Rezoning Transportation Analysis

Petition Number: #2022-044

Date	Description
08-19-2022	First Review (AO)
09-22-2022	Second Review (AO)
10-26-2022	Third Review (DR)

Transportation Summary

RZ-1

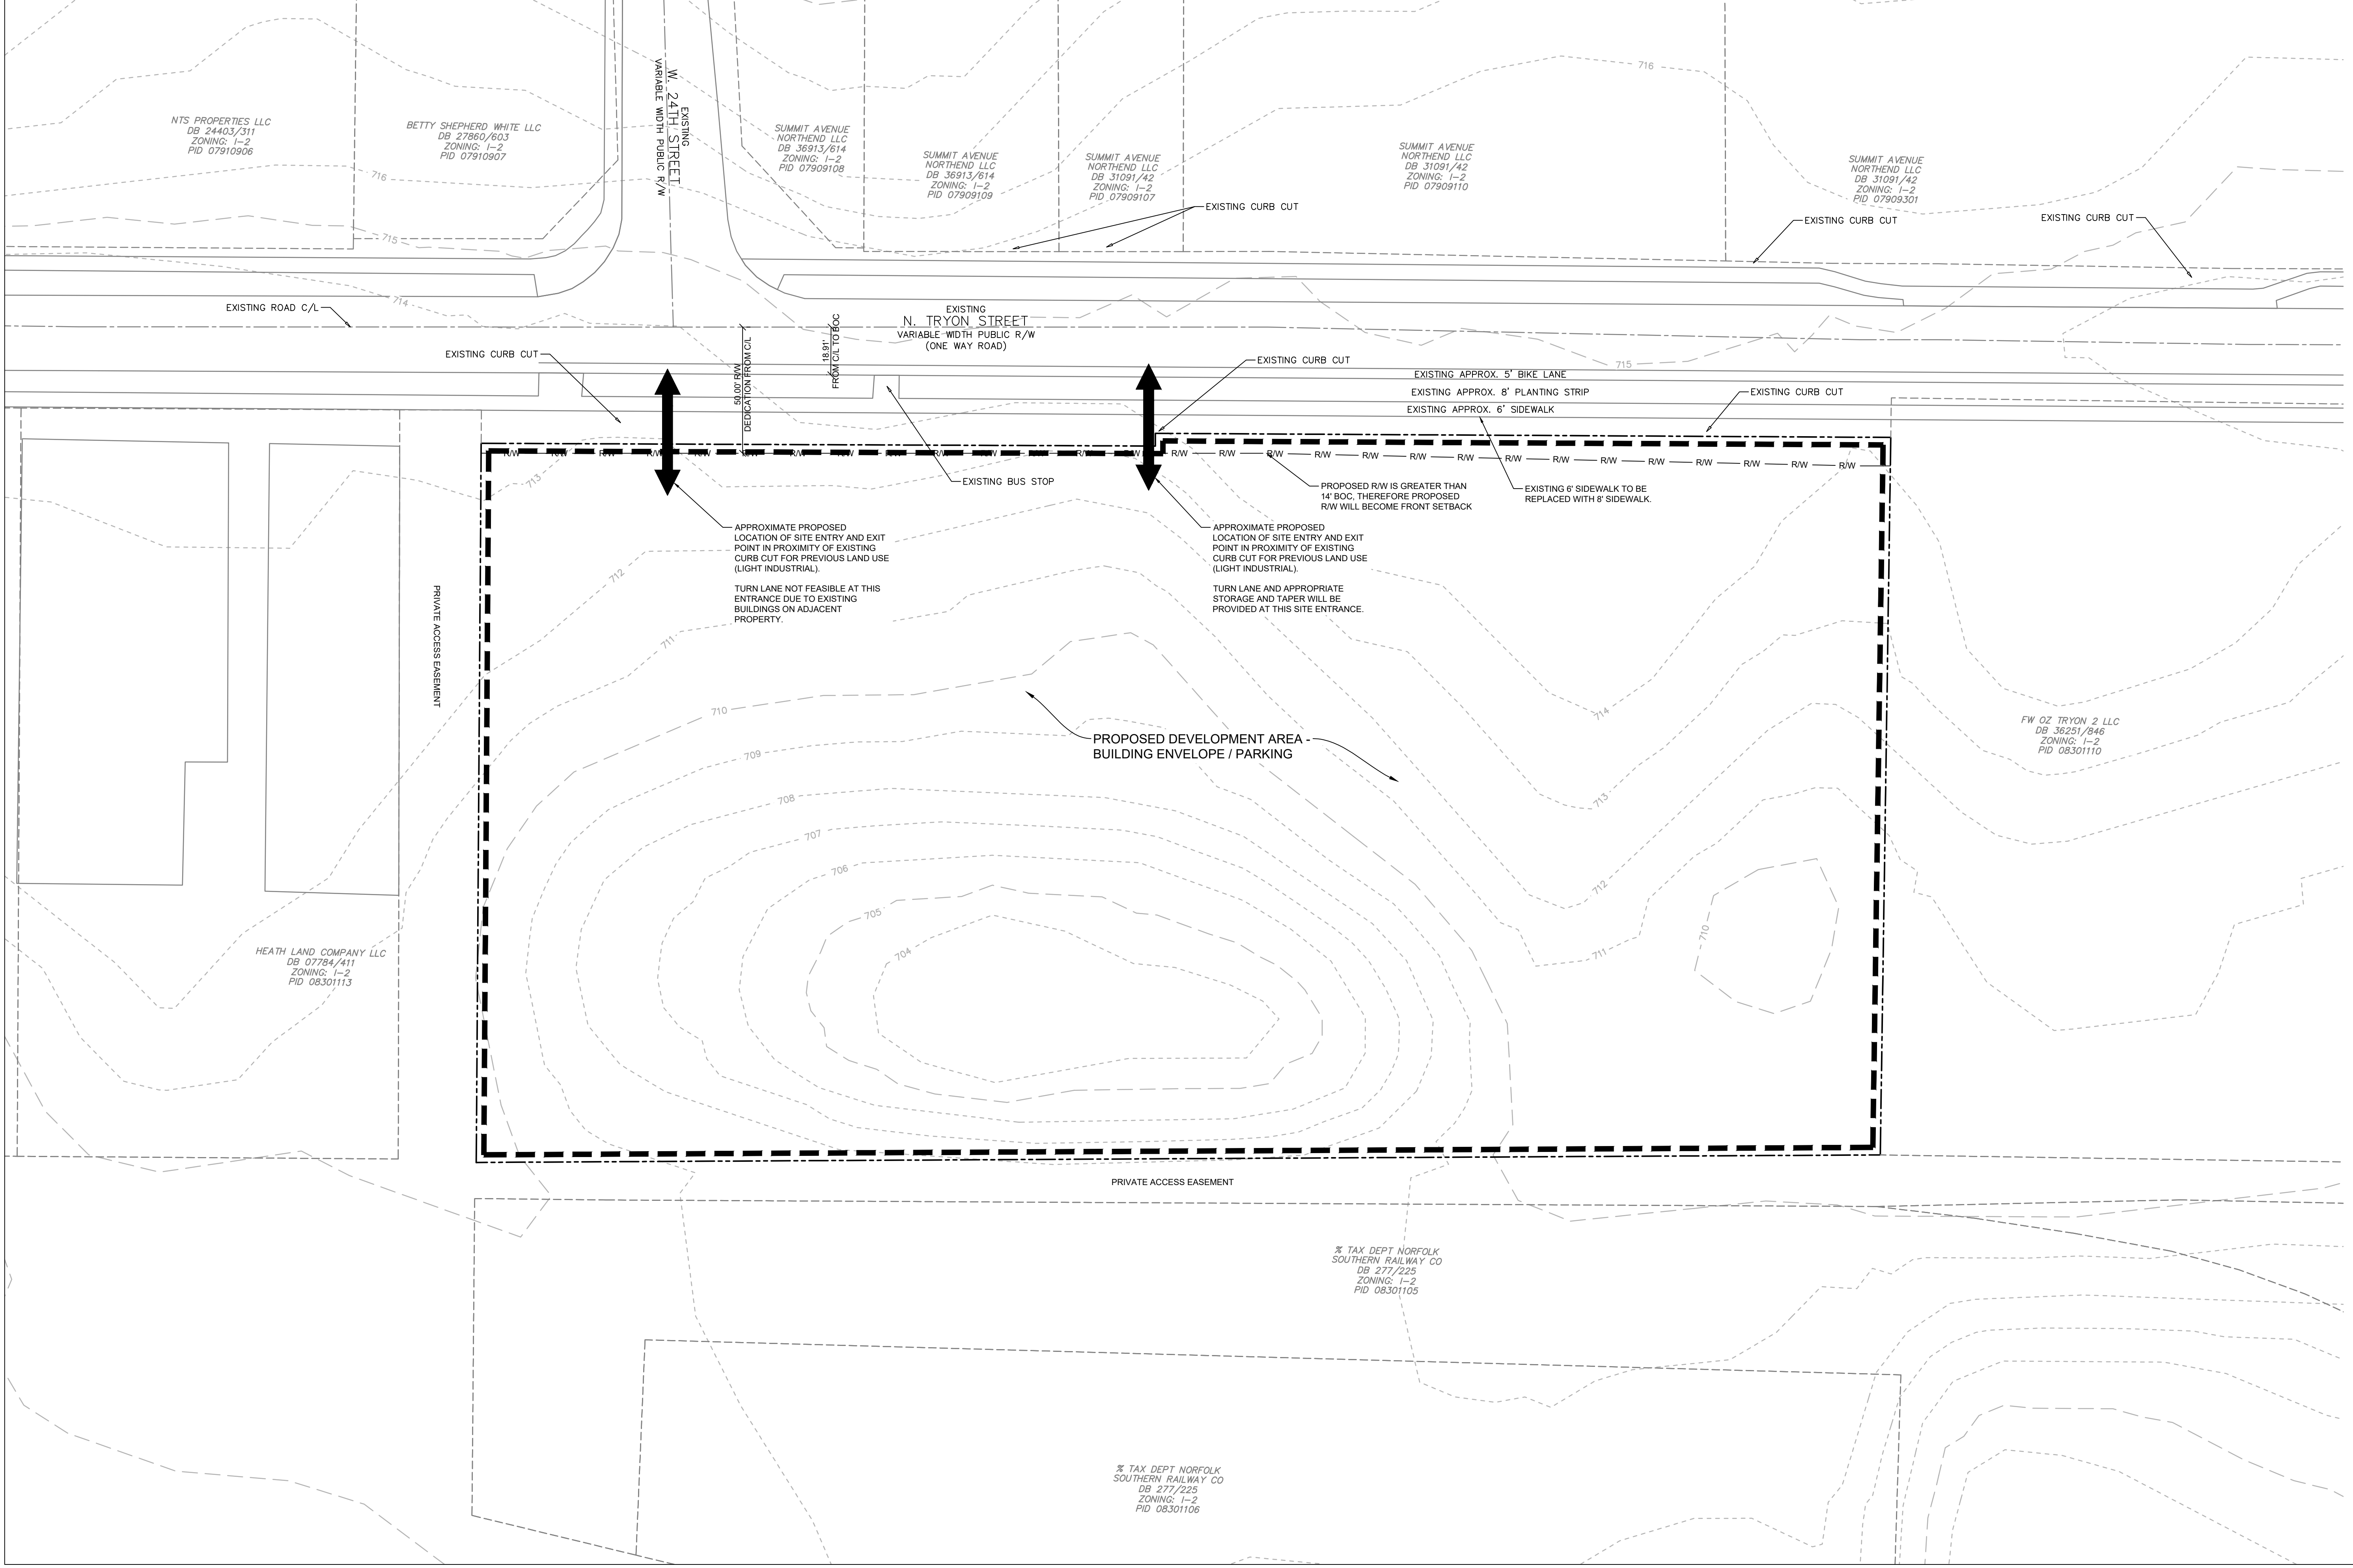
6. ~~Resolved: Outstanding Comment from 8-19-22:~~ Revise site plan and conditional note(s) to commit to constructing a right turn lane with 100' of storage and appropriate taper on N Tryon St at proposed access points per NCDOT requirements.
~~Update to Comment (New Site Plan, 9-12-22): If a turn lane can't be provided at the site access it must be removed from the Rezoning Plan per NCDOT. It appears that further coordination with NCDOT is required. Include a layout of the proposed right turn lane on site plan. Second drive limited to exit only per revised plan.~~

10. **Resolved: New Comment (New Site Plan, 9-12-22):** Revise site plan removing existing driveway cuts only showing proposed access points for clarity. Note that existing curb cuts are to be removed

RZ-1

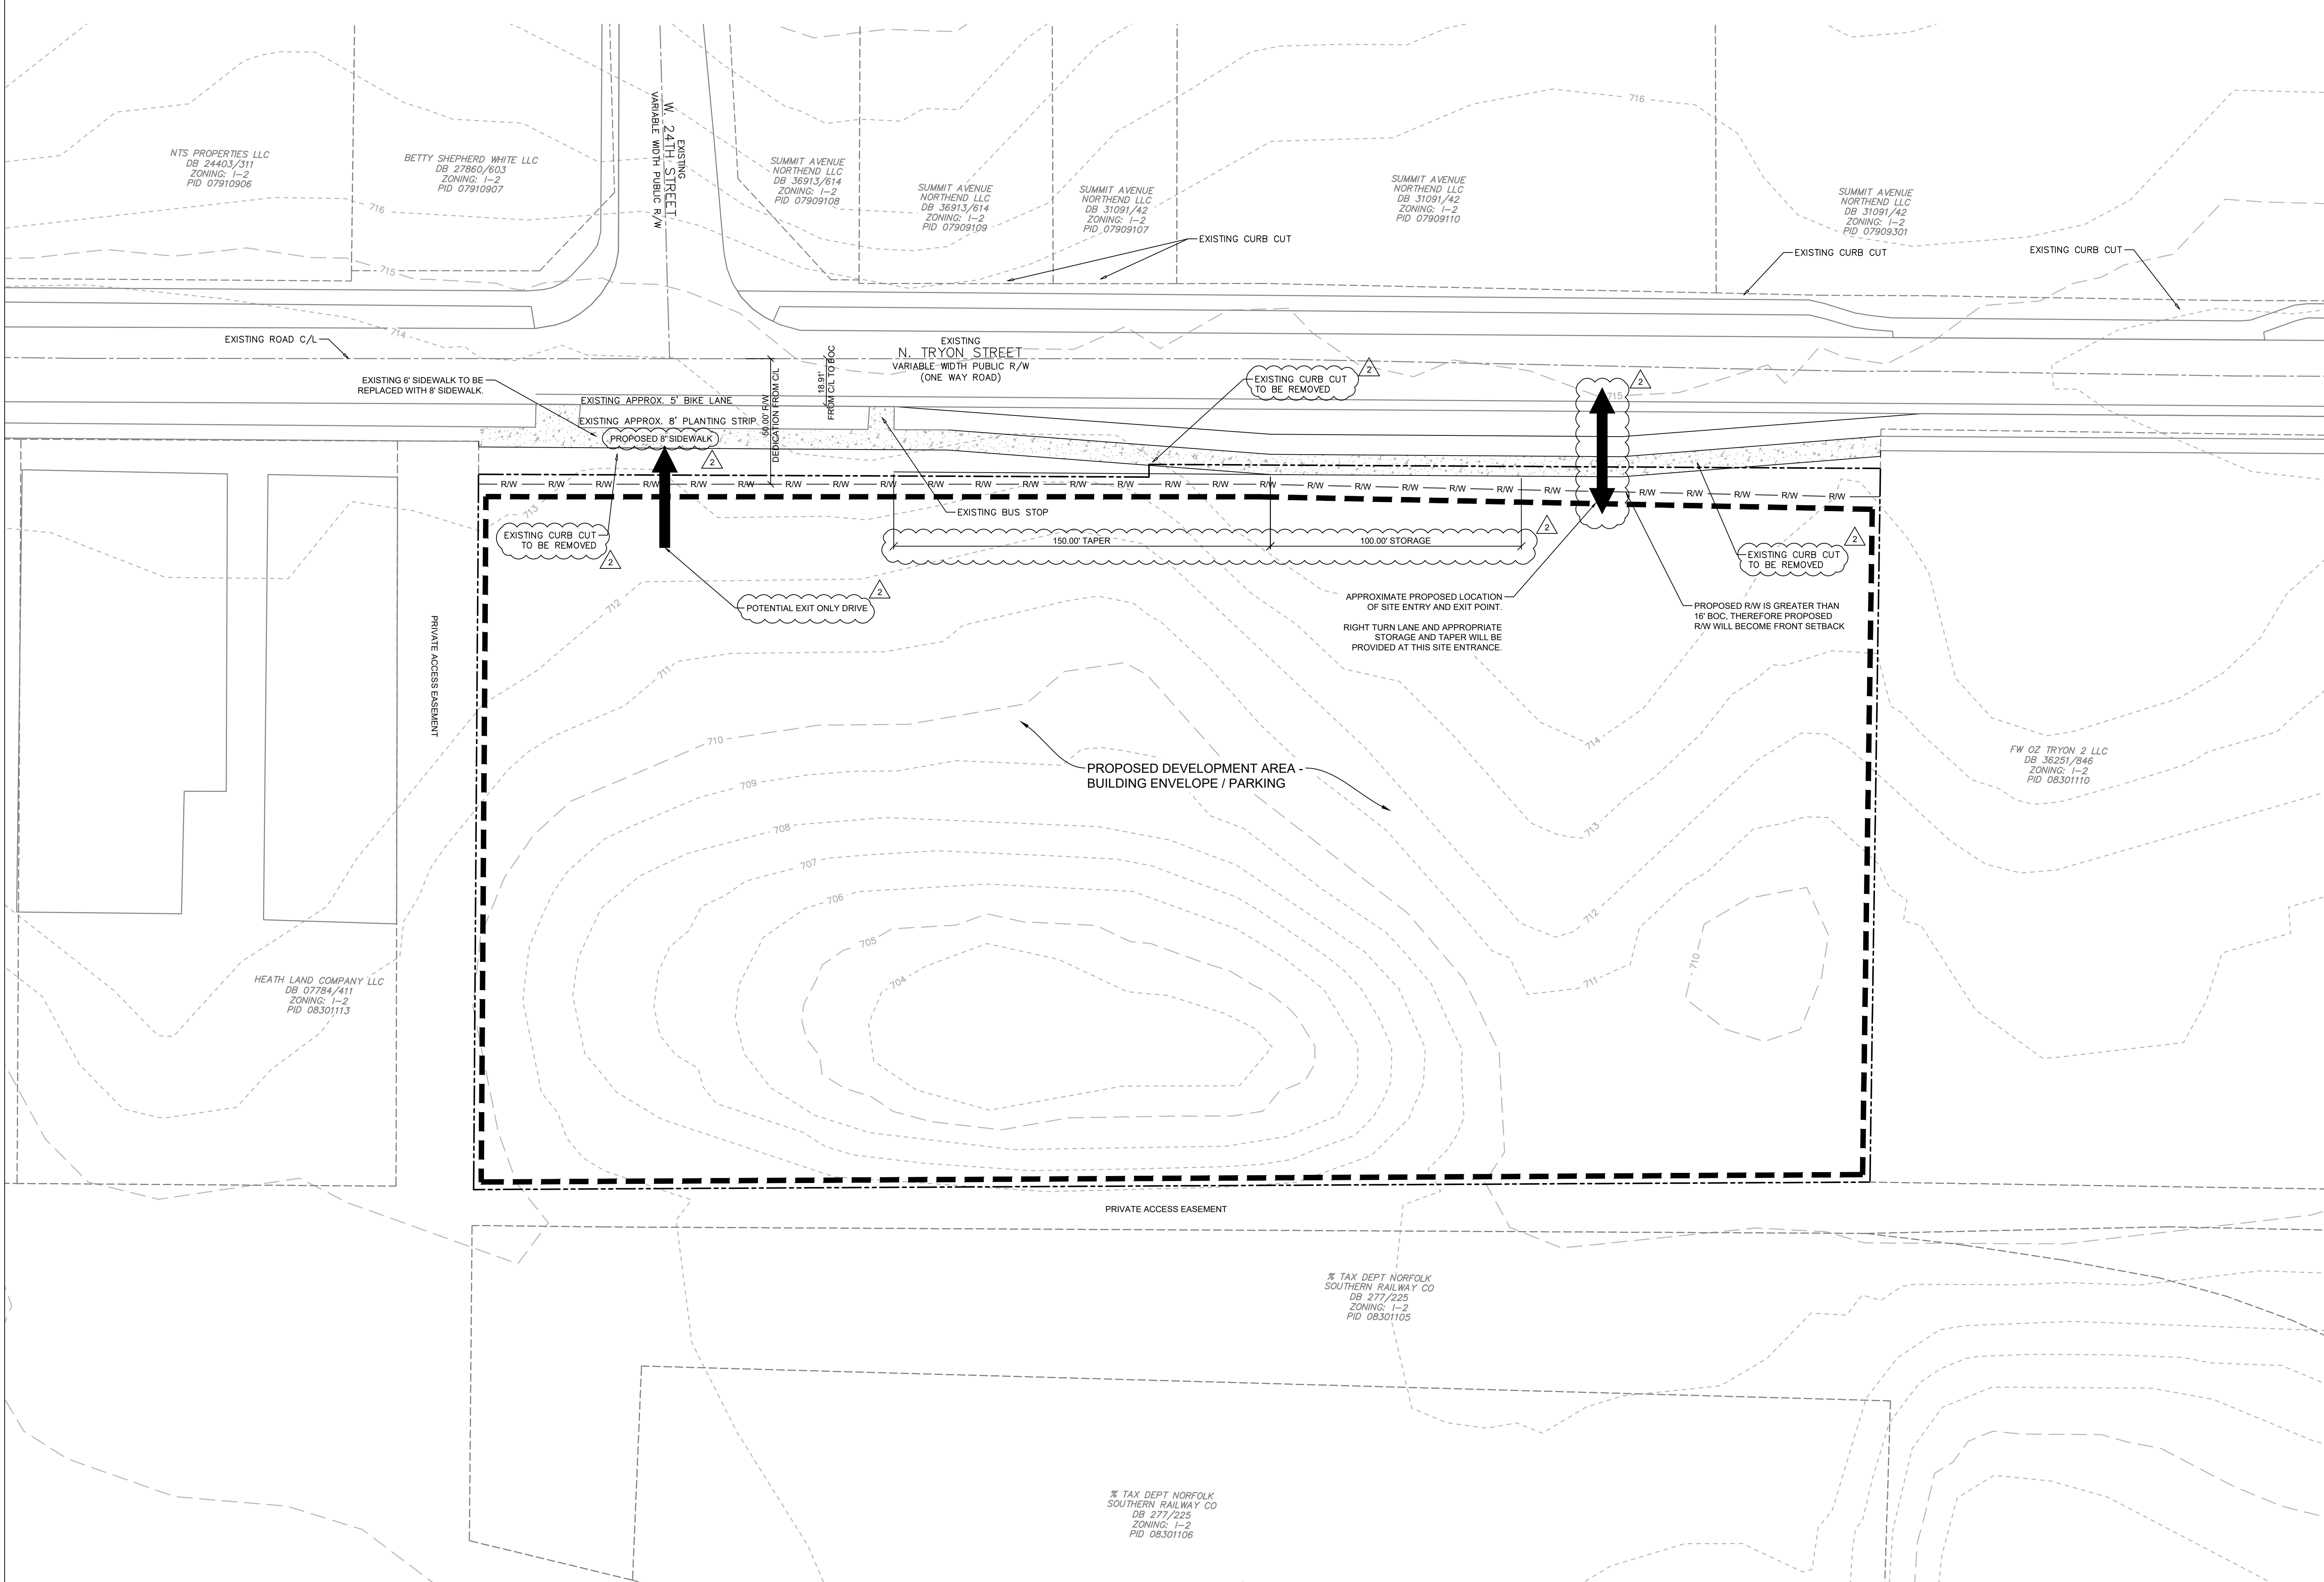
11. ~~Resolved: New Comment (New Site Plan, 9-12-22):~~ Revise Transportation note IV.a. to add NCDOT in addition to CDOT.
